DOC21/666127-17

31 August 2021

**Sell and Parker Kings Park Metal Recovery and Recycling Facility Expansion SSD 10396
EPA Advice on Submissions Report**

3. Graphed data measured in free-field; tabulated results facade corrected

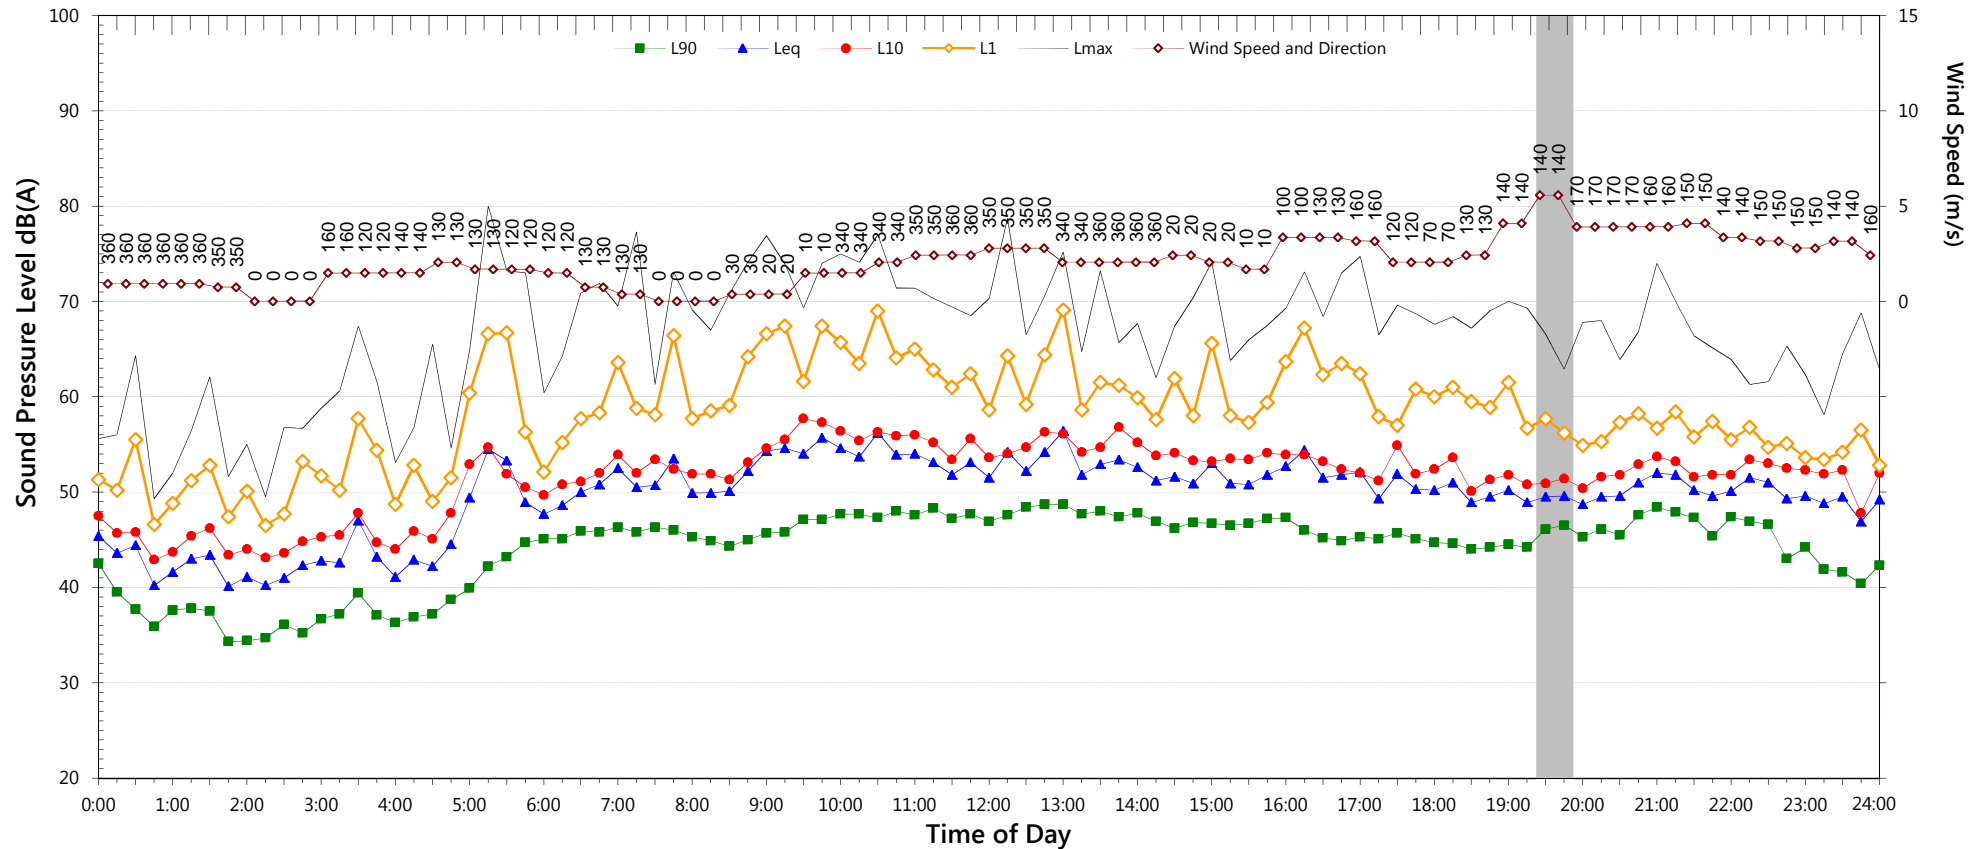
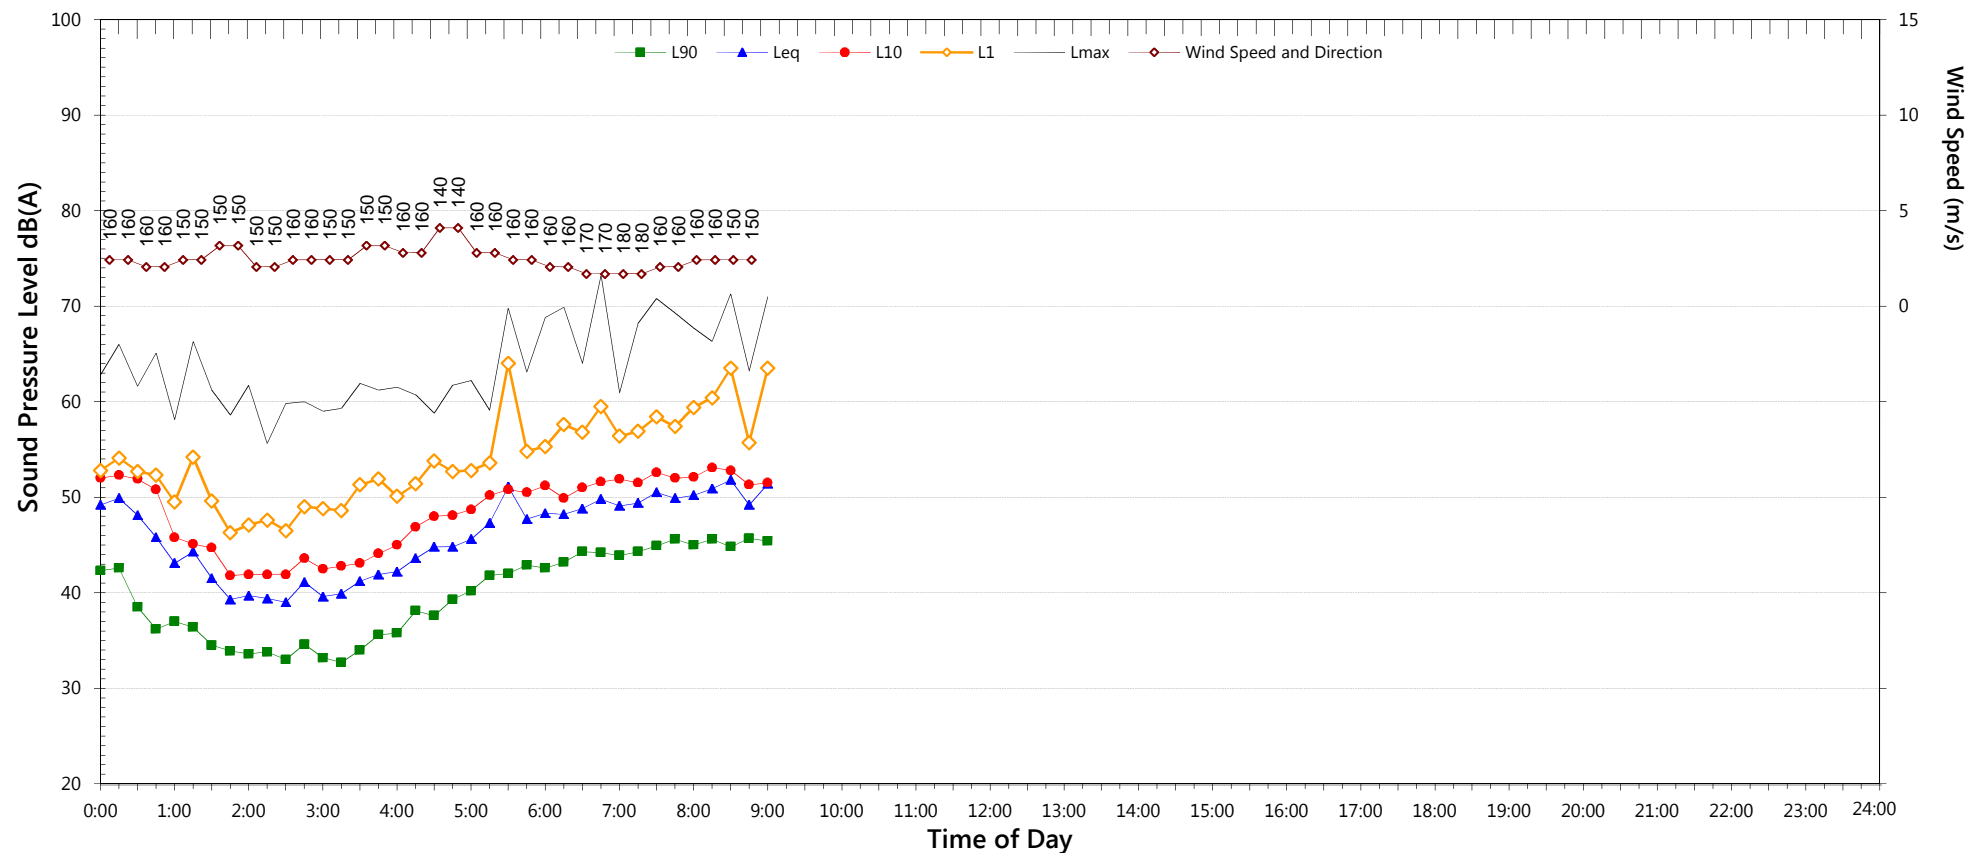
1. The prevailing noise environment for receivers in NCA 1B at an appropriate location further removed from Sunnyholt Road than 2 Anthony Street Blacktown;

<p>There is uncertainty with the noise data used to inform the Project Noise Trigger Levels and sleep disturbance criteria.</p> <p>The EPA does not concur with the Project Noise Trigger Levels and sleep disturbance criteria presented in the assessment due to the issues raised with the characterisation of the existing acoustic environment in the area as outlined in the comments above. The criteria presented in the NIA, Section 6 needs to be reviewed in terms of the issues raised.</p> <p>The proponent must review and confirm, or amend if and as appropriate, the noise data used to inform the Project Noise Trigger Levels and sleep disturbance criteria taking into account the EPA’s comments above.</p>	<p>The Supplementary Noise and Vibration Impact Assessment (refer to Appendix C) has included additional long term noise monitoring at four locations between 11 February and 24 February 2021. This long-term noise monitoring was used to determine the Rating Background Levels (RBL) and representative ambient noise levels in accordance with the NSW ‘Noise Policy for Industry’ (NPfl). The project noise trigger Levels and sleep disturbance criteria have been updated based on the more recent monitoring data. In consideration of the updated project noise trigger Levels and sleep disturbance criteria, including prevailing meteorological conditions, noise emissions for all receivers comply with relevant project noise trigger levels without any additional noise mitigation measures.</p> <p>Nonetheless, as part of the commitment to continuous improvement and to reflect comments provided within community submissions, Sell &</p>	<p>See comments above regarding concerns about the background noise monitoring undertaken for NCA 1B and NCA 2.</p> <p>Additionally, the project amenity noise level derived in the Supplementary NIA adopts “urban” residential noise amenity area. The zoning of all residential locations is R2 which according to the NPfl, Table 2.3 would attract a “suburban” residential noise amenity area.</p> <p><u>The selection of “urban” needs to be justified.</u> Any justification needs to consider ambient noise levels and sources, and in the case of NCA1B the ambient environment of locations further removed from Sunnholt Road (i.e. not 2 Anthony Street).</p>
